October 26, 2022

**Re: Project no. PR-2022-007701, Application no. SI-2022- 01868
New Branch office for Nusenda Credit Union at 2801 Juan Tabo NE, Abq NM.**

The following are responses describing how we comply or are addressing staff comments to follow IDO and other requirements for site plan approval:

SITE PLAN

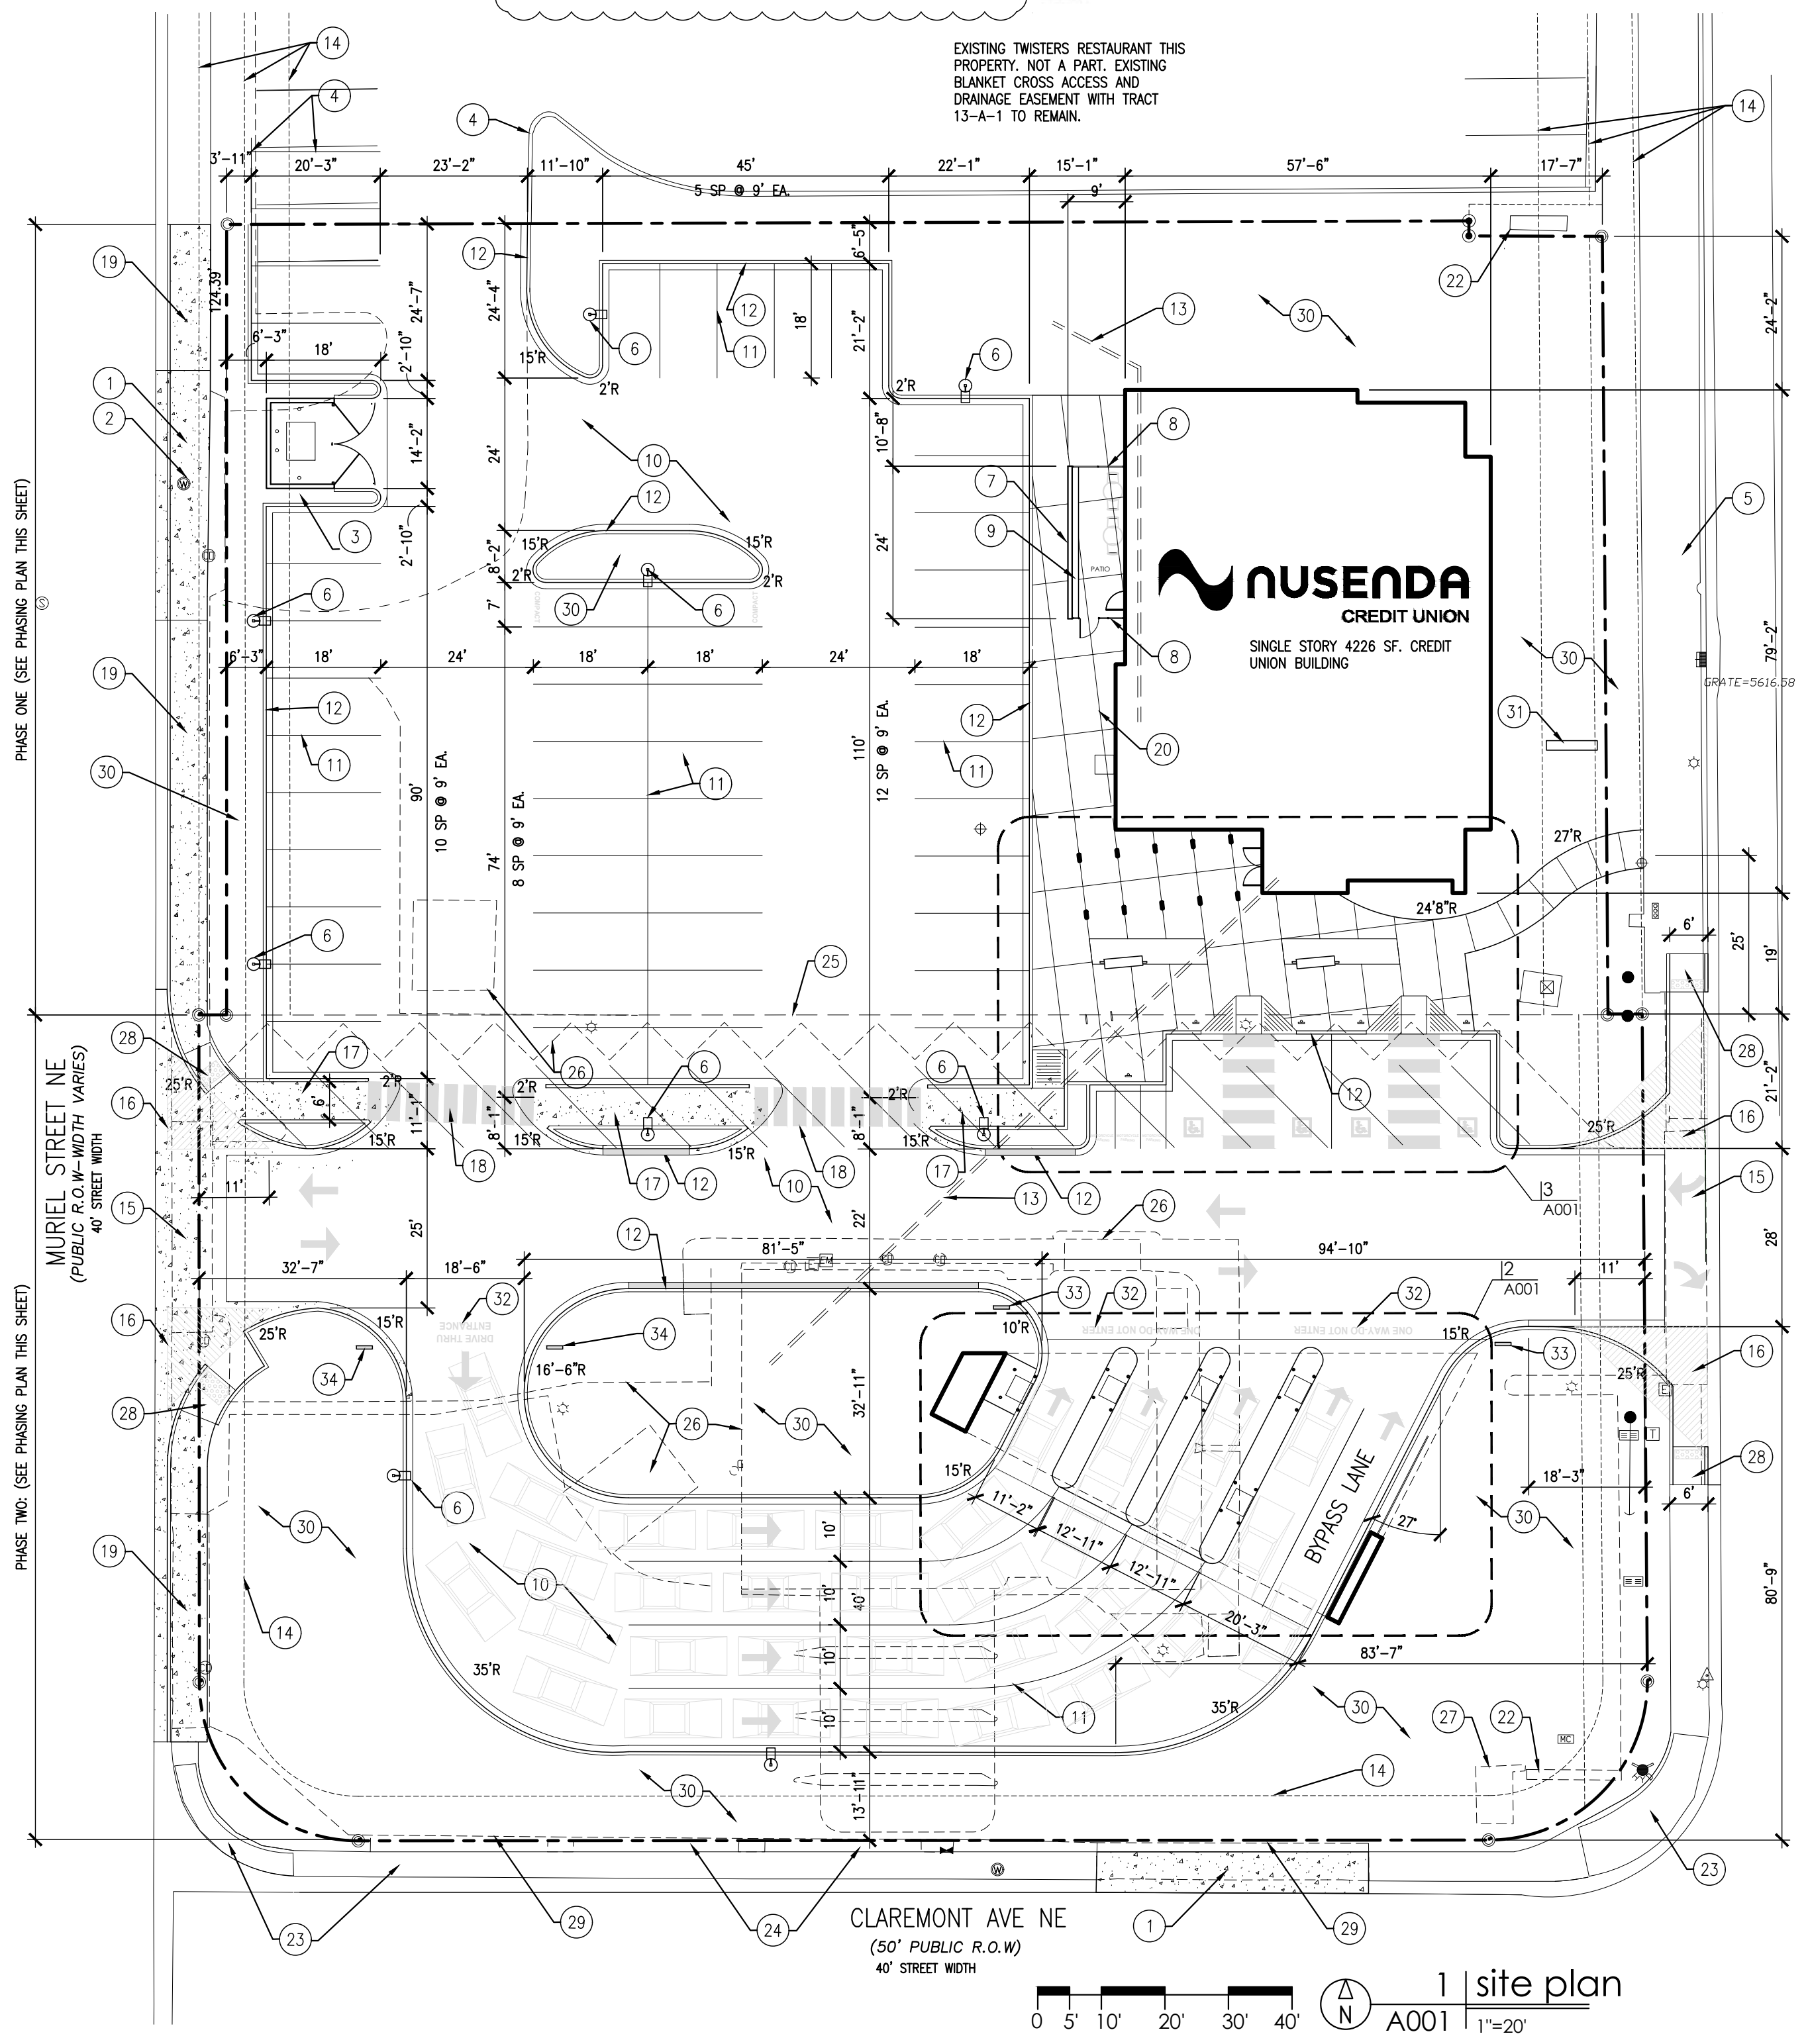
5. All sheets submitted have stamps from registered professionals. All future sheets submitted will be stamped by registered professionals.
6. The project number and application numbers have been added to the site plan (attached.)
